File Ref: SSD-27208140

16 December 2021

**RE: St Aloysius College - Rozelle Campus**

**Property: 2A-2B Gordon Street & 48 Victoria Road, ROZELLE**

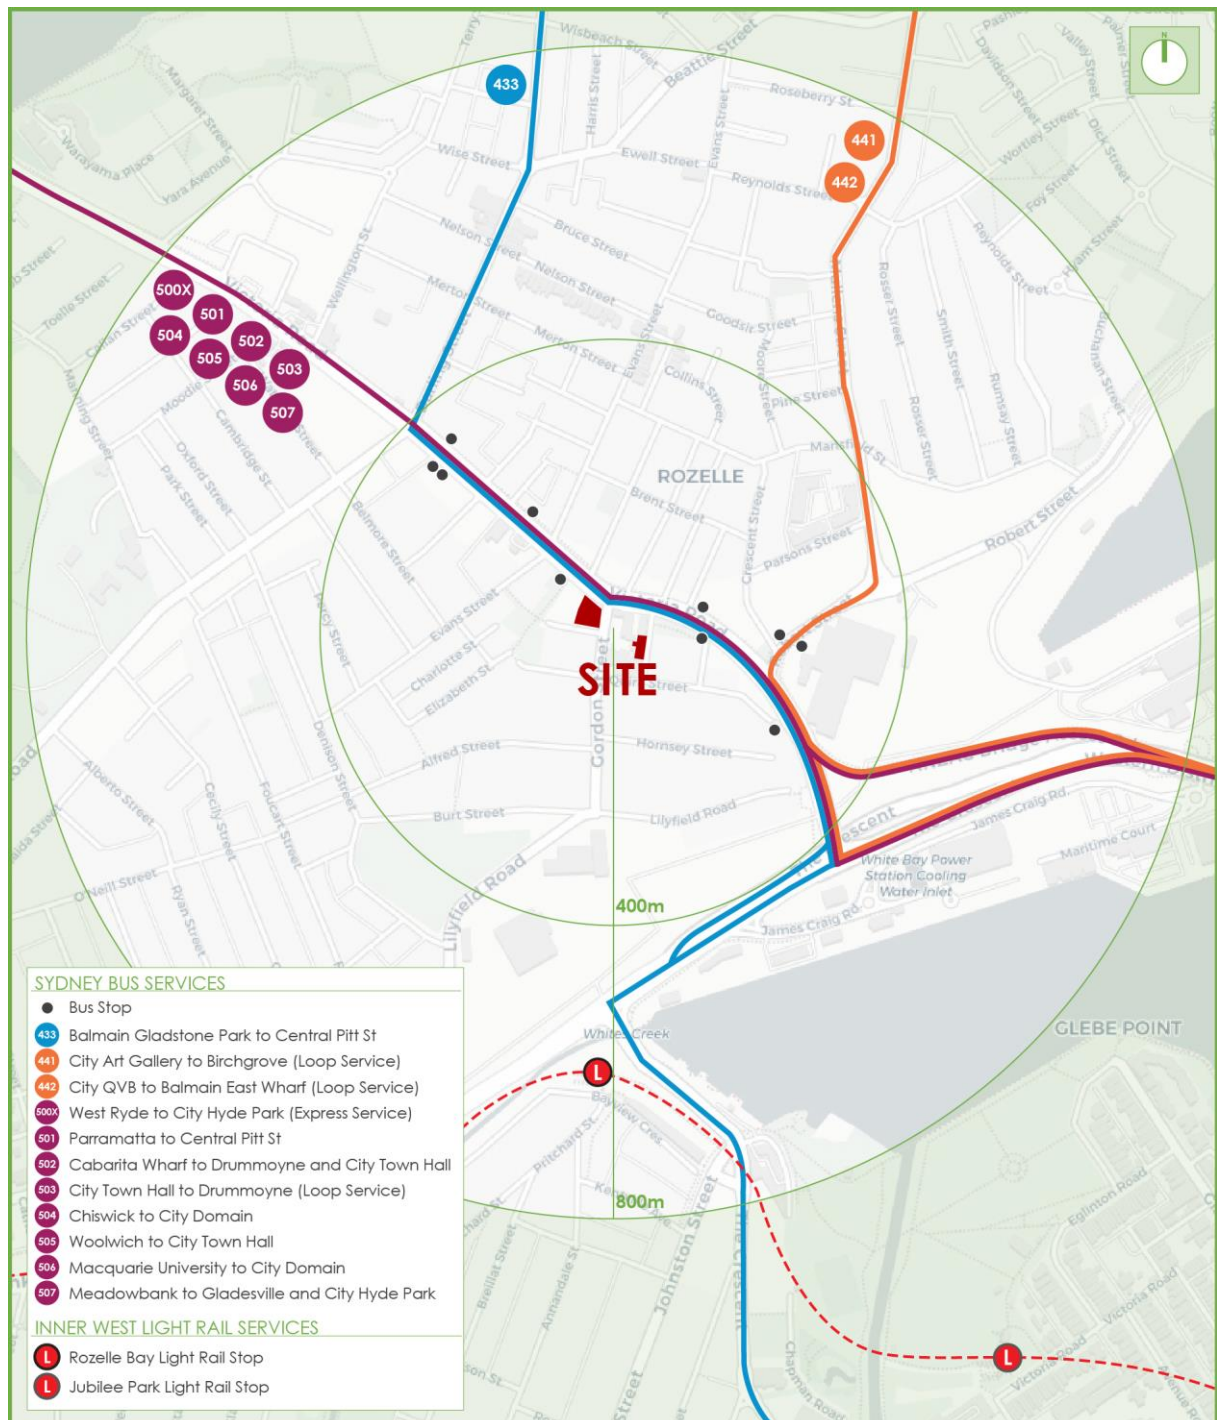
- i. Objection is raised to the proposed use of Bus Zones in Victoria Road for set down or pickup of passengers. Private coaches are not permitted to use these Bus Zones and no alternative has been provided.
